7/11/2016

Kittitas County
Community Development Services

Re: Big Creek PUD

Illustrative Master Plan
Big Creek
 A Planned Unit Development
 Kittitas County, Washington

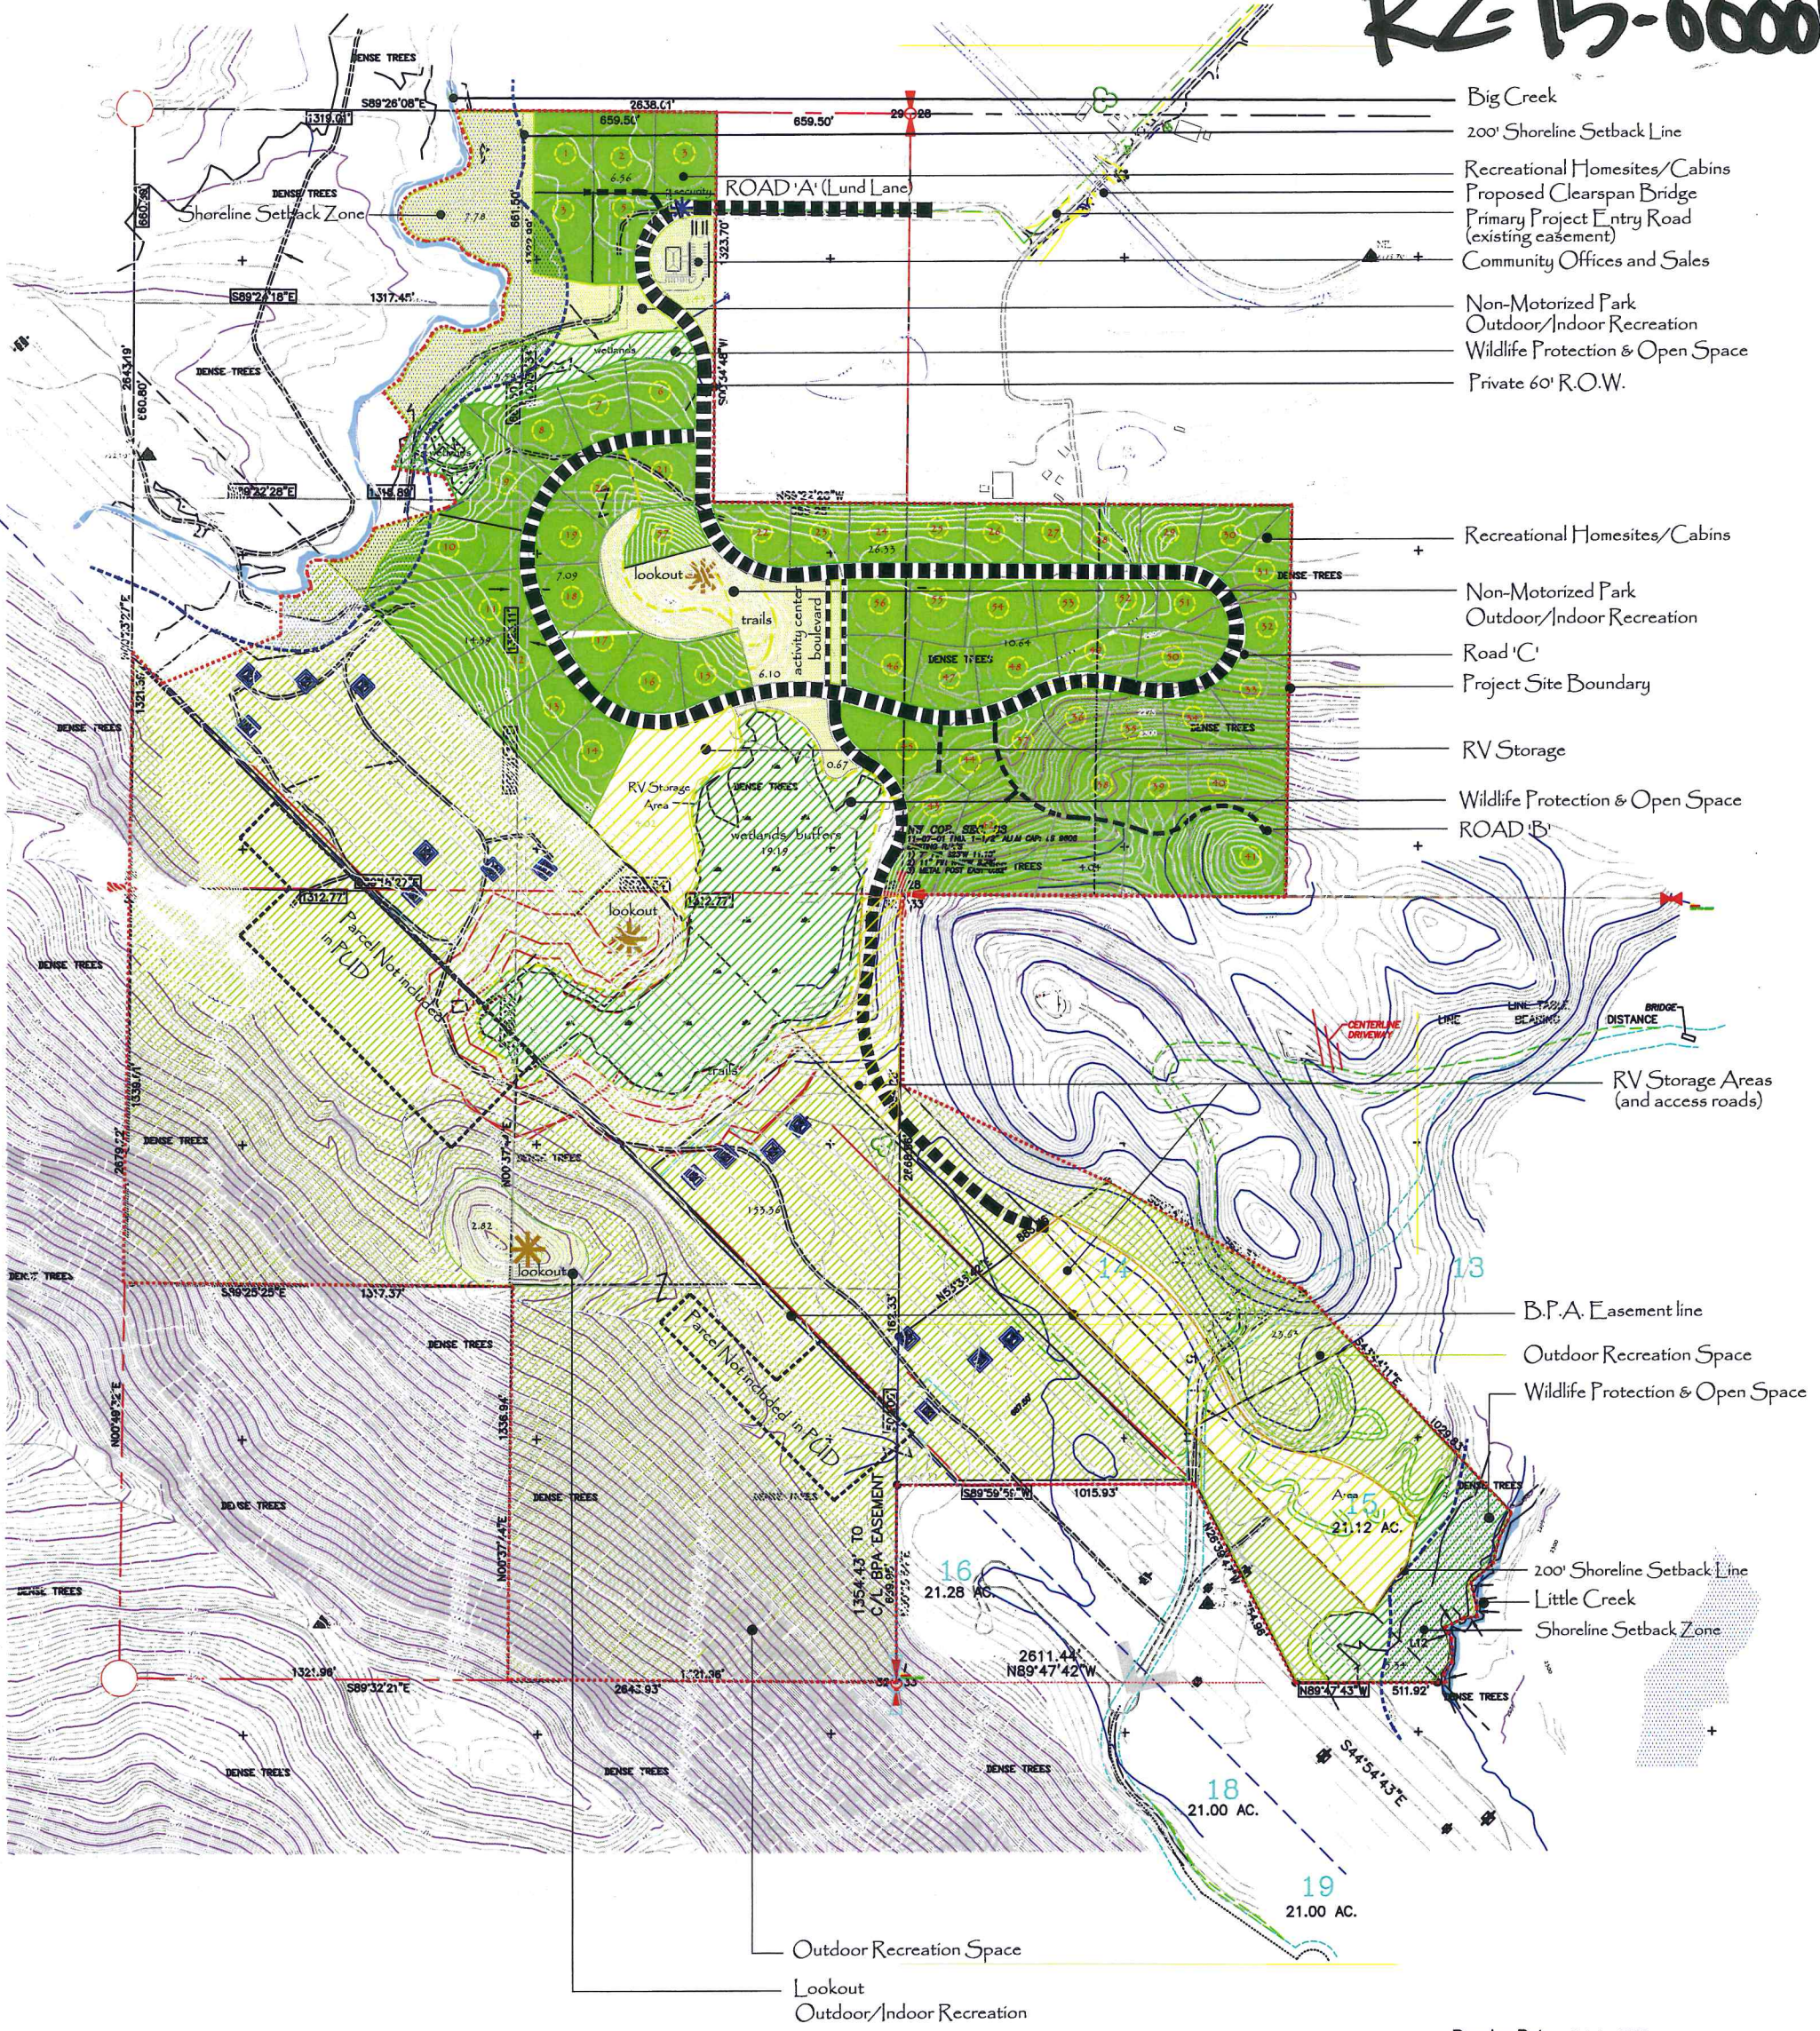
The easement routes are within Mr Deneen's planned short plat. And will be disrupted by his transportation plan for the short plat.

Supplied review material indicate the roads will be private 60 foot R.O.W. Monatree, LLC request that any approval of Big Creek PUD require Mr. Deneen to construct a replacement road to the west boundary of the SE $\frac{1}{4}$, SW $\frac{1}{4}$ and an easement for such road be issued to Monatree, LLC.

The Monatree, LLC acreage is held as designated forest land. The land will receive any and all types of forest management activities. Plus the PUD roads will receive heavy equipment and log transportation.

After road construction approval and

receipt of replacement easement the LLC will be agreeable to cancellation of current easements
